# Dean Moor Solar Farm

## Environmental Statement: Chapter 6 – Figure 6.1 Designated Heritage Receptors on behalf of FVS Dean Moor Limited

August 2025  
Prepared by: Stantec UK Ltd  
PINS Ref: EN010155  
Document Ref: D2.22  
Deadline: 2  
Revision: 2

<b>Project Ref:</b>	<b>EN010155/6.2</b>	<b>ES</b>
	<b>Figure 6.1</b>	
<b>Status</b>	Final	
<b>Issue/ Rev:</b>	2	
<b>Date:</b>	August 2025

Client	
FVS Dean Moor Limited	
Title	
DEAN MOOR SOLAR FARM DEVELOPMENT CONSENT ORDER	
Designated Heritage Receptors within 3km of the Order Limits	
Scale: 1:35,000 @ A3	Date: 04/11/2024
Drawn: TL	Checked: HC
Figure: 6.1	Sheet 1 of 1
Rev: A

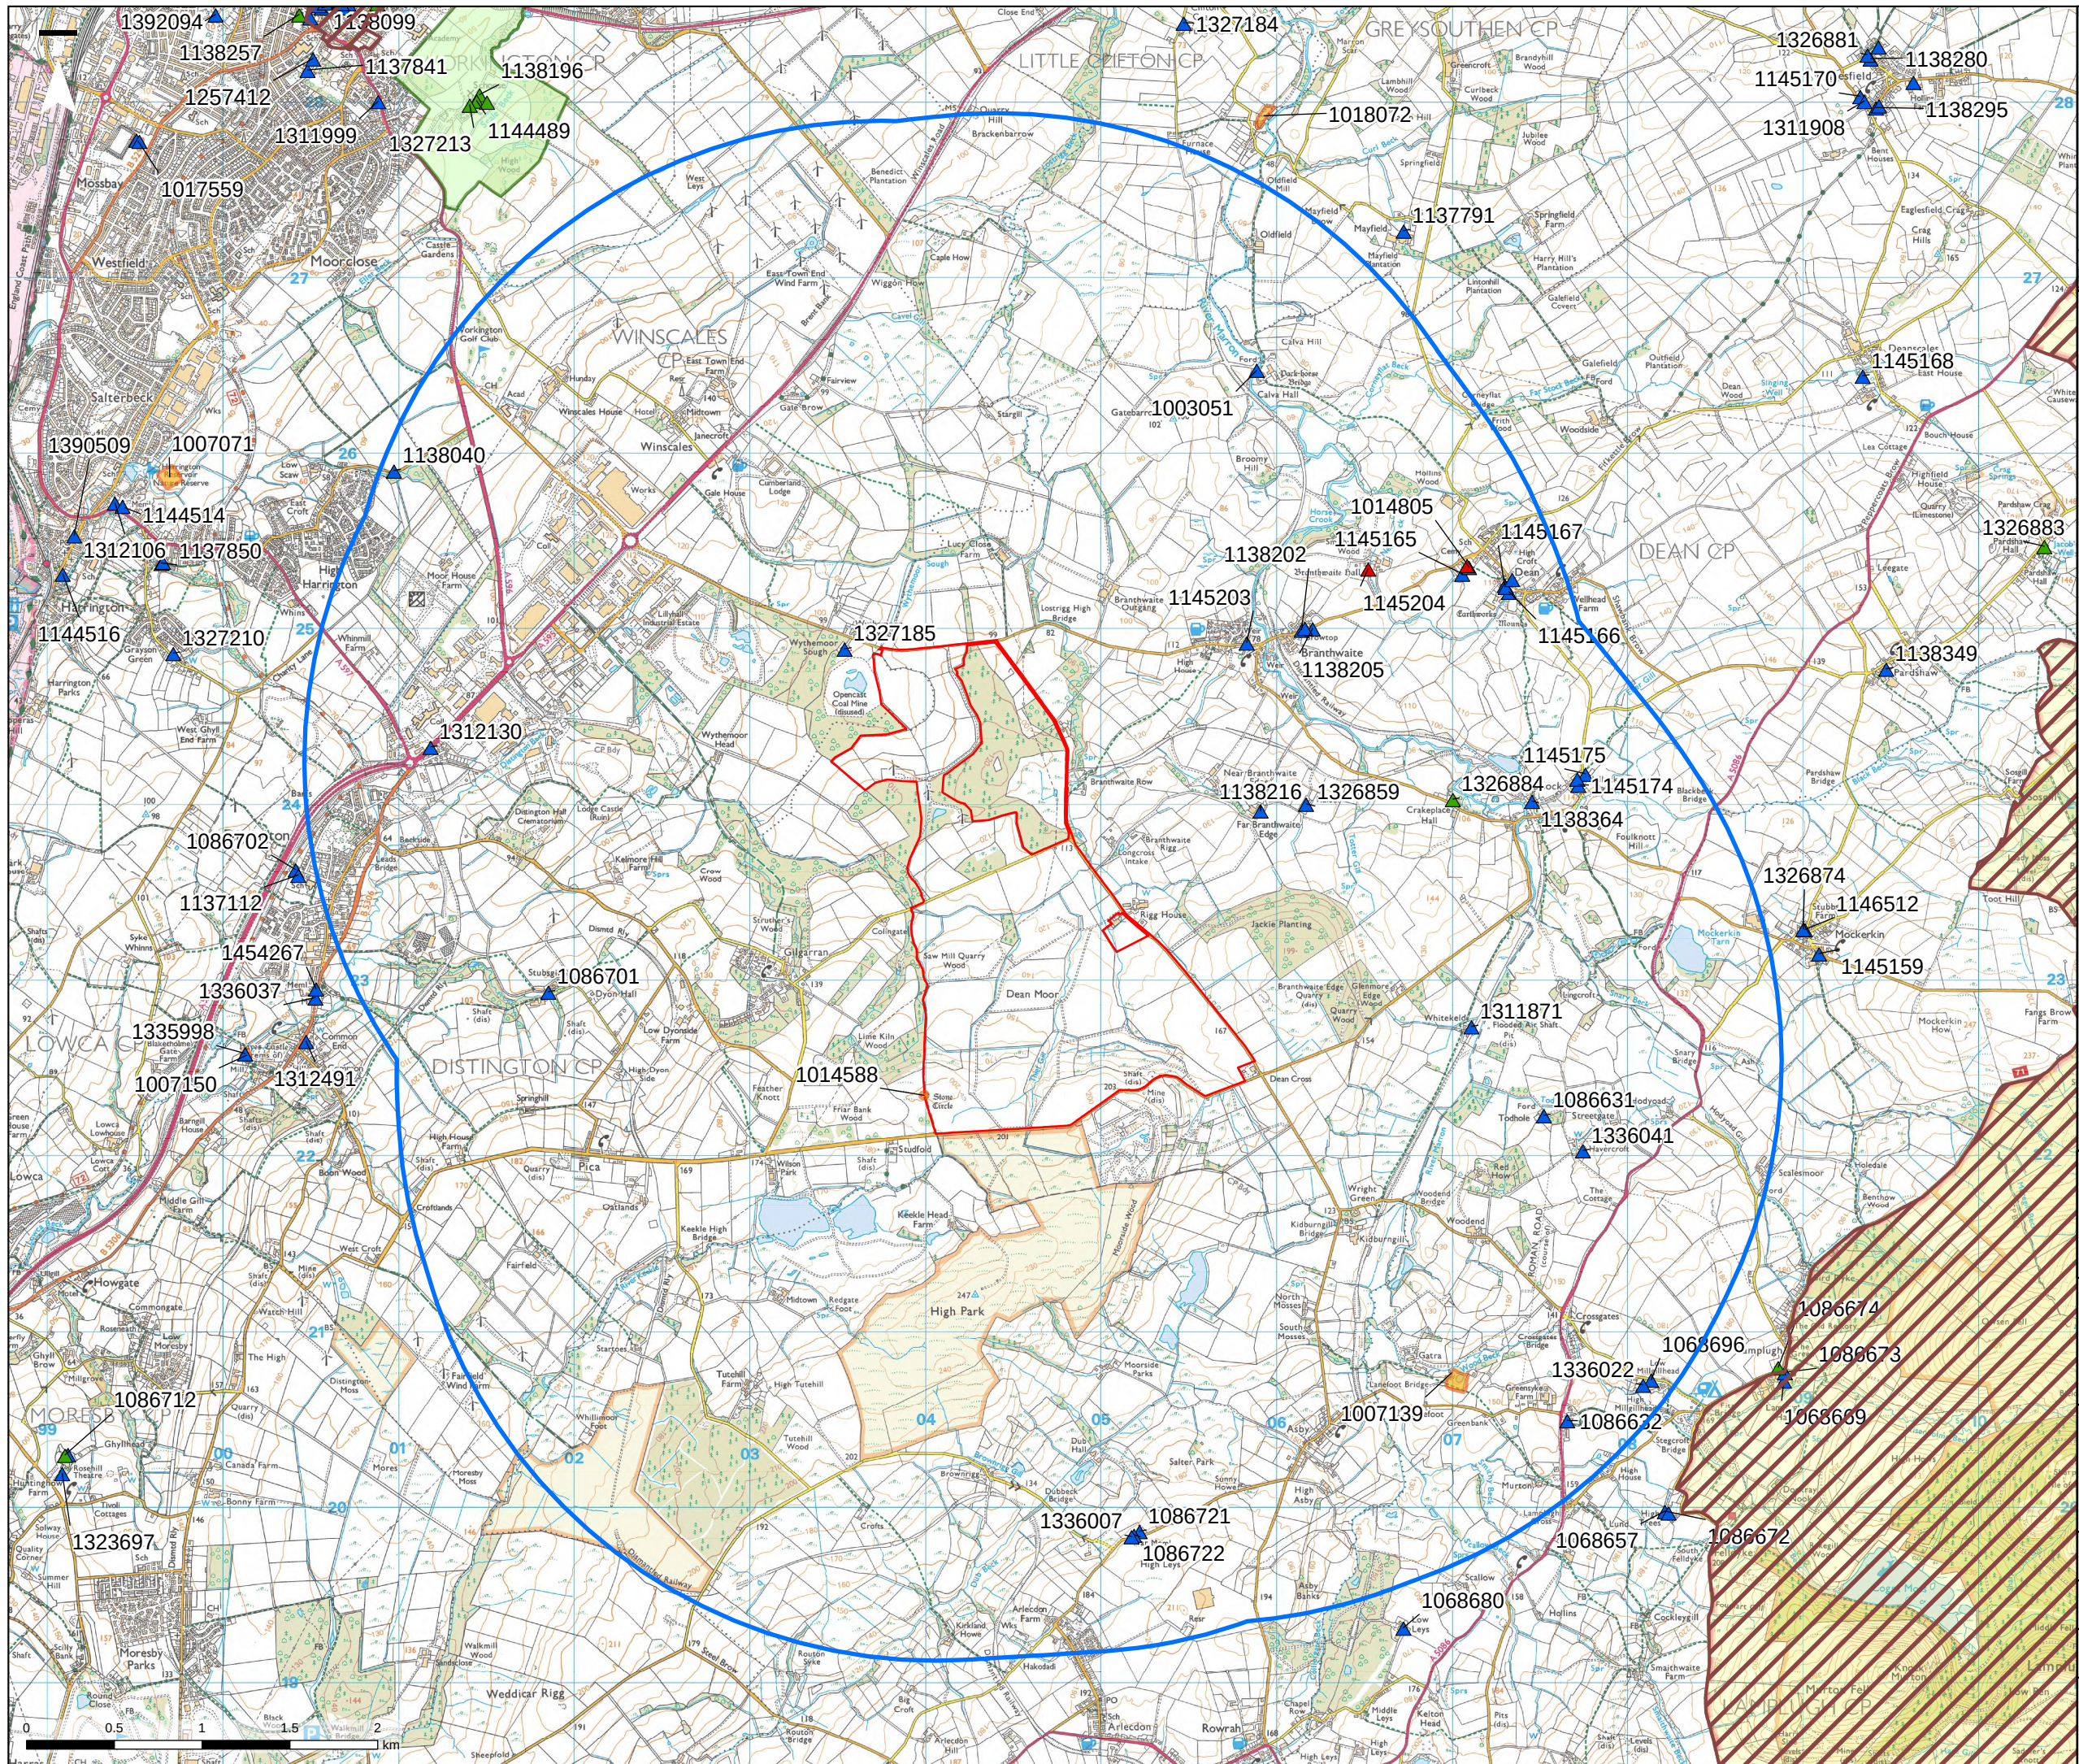
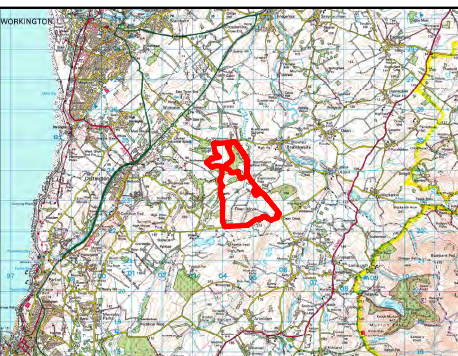
Revision	Reason
Removal of hatching pattern distinguishing a Conservation Area from the English Lake District World Heritage Site	<p>As part of the Examiner's questions, the Examiner pointed out in Q5.0.10 that <i>"The figure showing Heritage Assets within 3km [APP-076] illustrates that the boundary of Conservation Areas is identical to the boundary of the WHS. Please amend the plan if it is incorrect."</i></p> <p>The figure has therefore been updated to correct this error.</p>
